EPC STORMWATER REVIEW COMMENTS
IN ORANGE BOXES WITH BLACK TEXT

GUNTZELMAN PORCELAIN PINES SUBDIVISION

GRADING AND EROSION CONTROL PLAN

COUNTY OF EL PASO, STATE OF COLORADO
FEBRUARY 2023

SITE MAP
SCALE: 1" = 200'

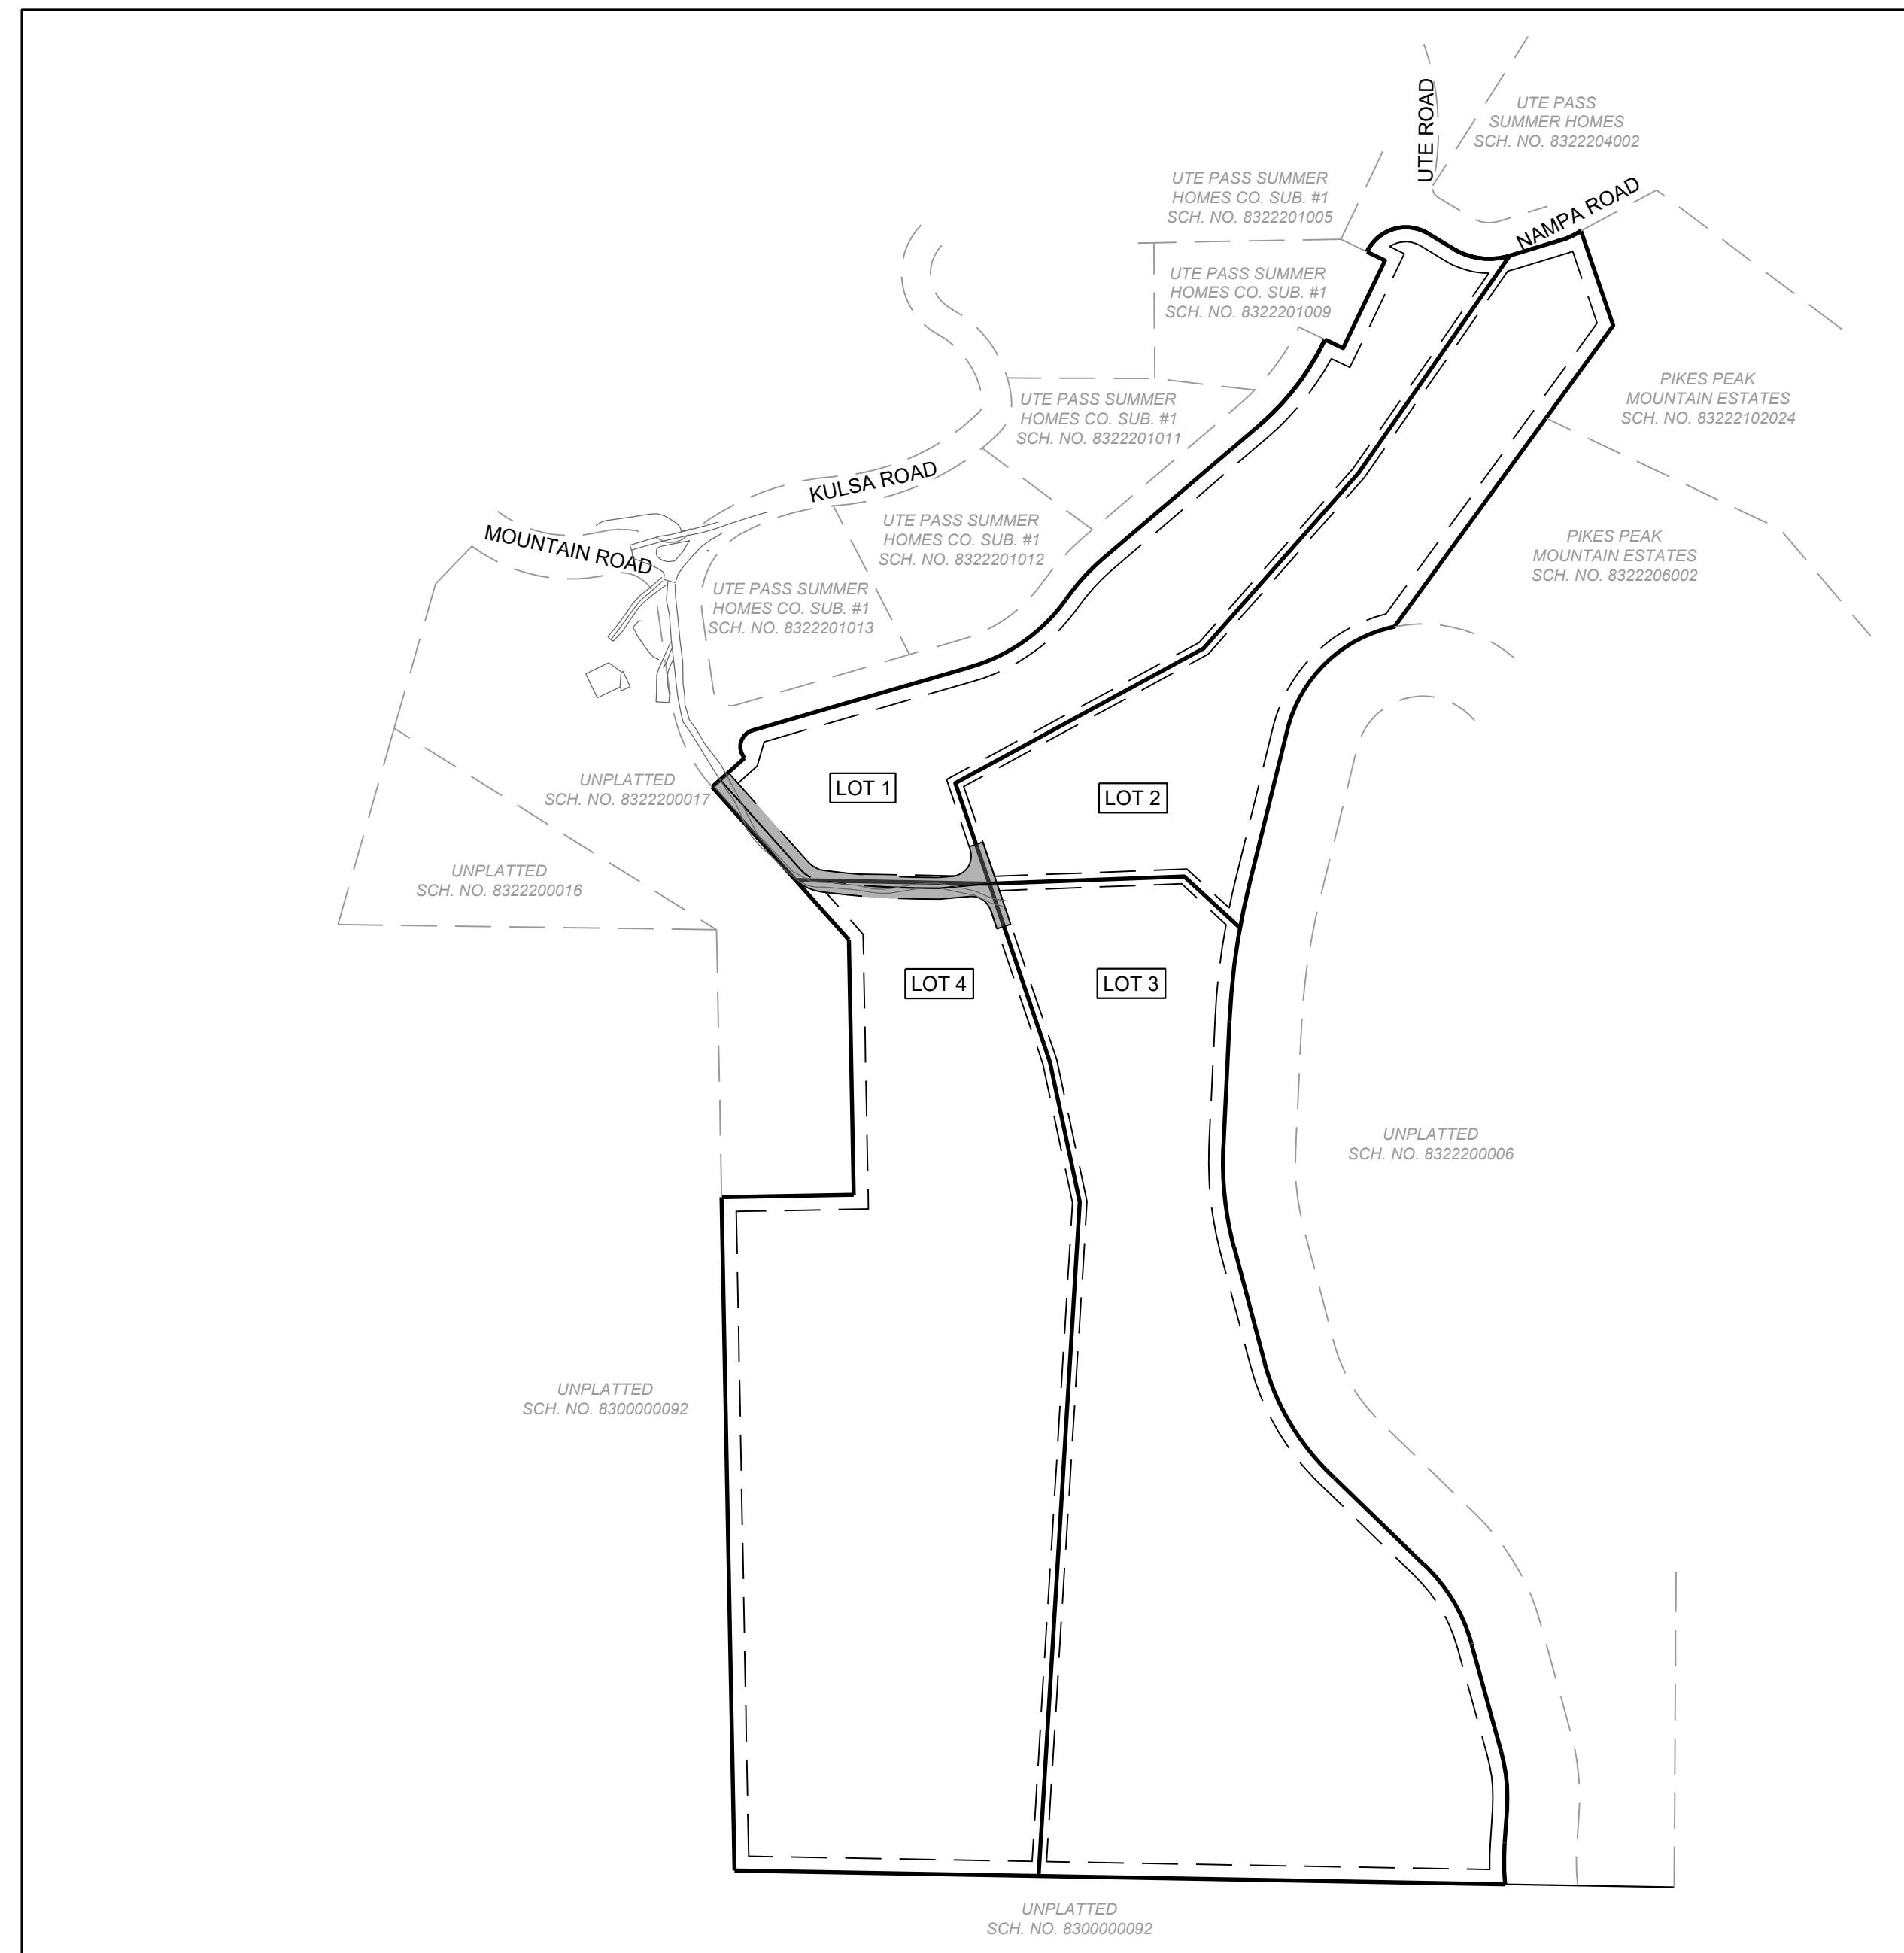
If these plans are to include all of the GEC design information and the road design information these should be CDs with the GEC plans inserted into them. Or the GEC's can be kept separate and the design information for the road and all required details need to be added to the CDs (which currently only show the waterline).

GRADING & EROSION CONTROL PLAN

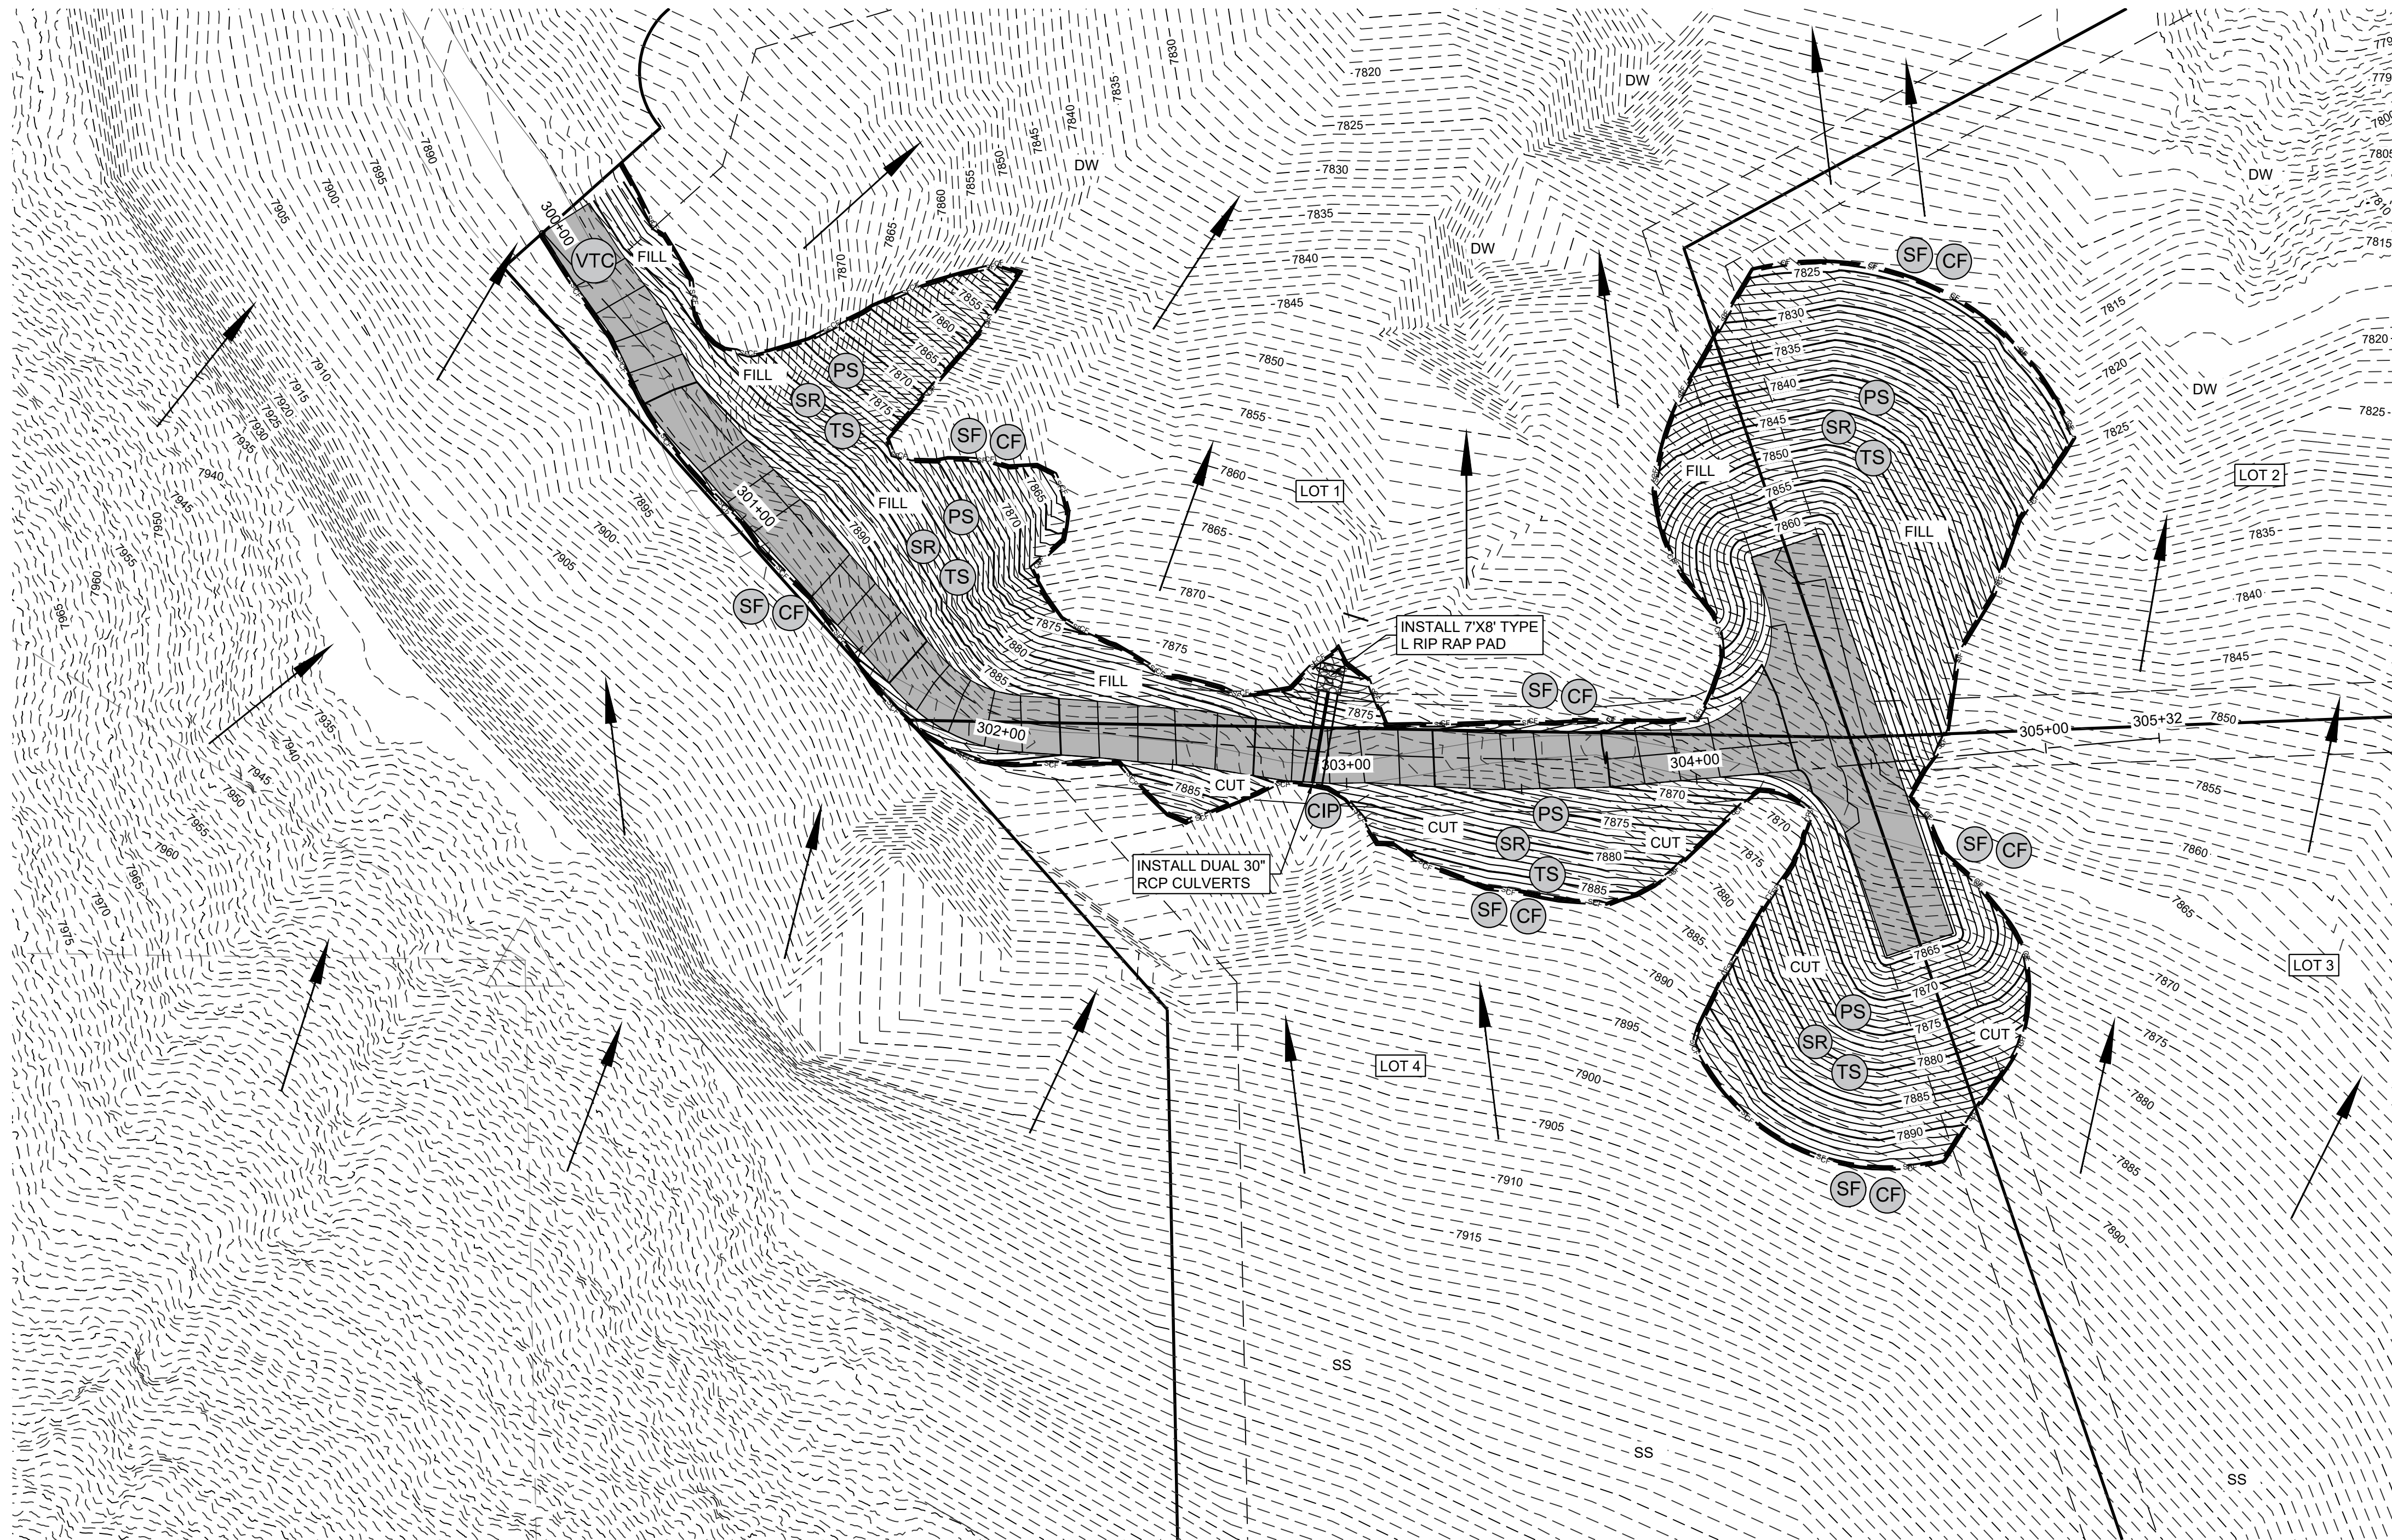
Consider expanding the limits of disturbance:

Provide CDs for proposed roadway work (including providing radii, riprap details, culvert details etc.) separate from the GECs. The CDs for the roadway work can be in the same set of plans.

GEC Checklist Item V. Label all proposed temporary construction BMPs by phase of implementation (initial, interim, final).

Provide shapes on the plans so the limits of the BMPs are clear

Put linestyle in the legend.

Provide ECB for slopes steeper than 3:1 and add to legend per SWMP.

Construction fence and limits of disturbance are located exactly at the edge of the proposed grading. Consider the constructibility of the grading and required staging areas. It is very likely more space will be required to allow for staging areas and room for equipment to complete the grading.

Provide a typical cross section of the driveway. Include the surface material type and thickness.

provide slope tags along the driveway.

Identify thickness of riprap pad

Label radius

Label radius

Label the width and length of the hammer head. Hammer head shall meet fire district requirements and international fire code.

Provide construction details for the dual 30" RCP culvert to include: invert elevation, minimum separation between culvert, endwall treatments (headwalls/wingwalls, or FES)

Provide the road centerline alignment bearing & distance information.

Label all slopes steeper than 3:1.

Label all property lines/easements.

Because the limits of construction/disturbance shown on the plans do not have any space between the limit and the proposed improvements, there is little room for the contractor to have a stockpile area, CWA, disposal areas, or staging areas. Whether or not the contractor will determine the exact location, that disturbance needs to be accounted for prior to the start of construction.

Per geotechnical report, slopes shall not exceed 3:1 slopes. Update grading where slopes are shallowing than 3:1.

To comply with the SWMP Checklist Item 17f, please add a note stating no batch plants will be utilized onsite.

Verify scale is correct. When measuring the plans using this scale I did not get the correct dimensions (station line should be 100'). Is the scale supposed to be 1"=30'?
